## Department of Primary Industries

### **Watermark Coal Project (SSD 4975) Response to exhibition of Environmental Impact Statement (EIS)**

### Watermark Coal Project (SSD 4975) Response to exhibition of EIS

Figure 24
Final Landform Catchment Boundaries

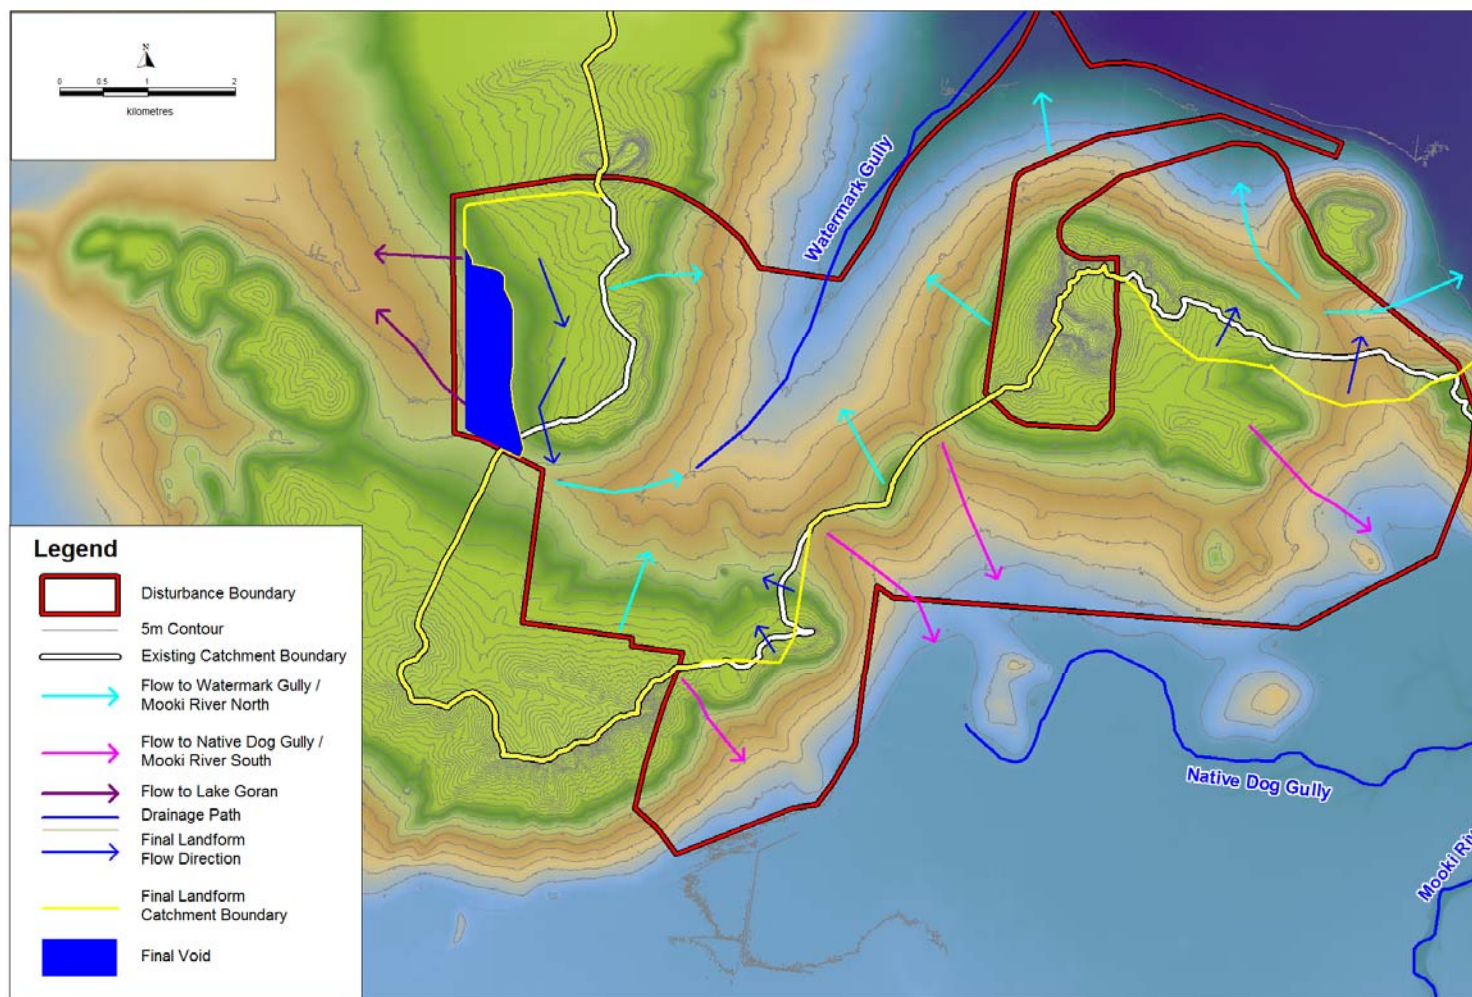
- (viii) The localised effect of flooding of Watermark Gully is a concern. Any impacts here may readily impact at the bottom section of Watermark Gully throughout all periods of the mine operation. As a result of the considerable changes to the immediate catchment, factors affecting runoff may vary substantially from year to year. The Office of Water would like to review in more detail what infrastructure may be proposed at the bottom section as this is not clearly explained in the EIS.
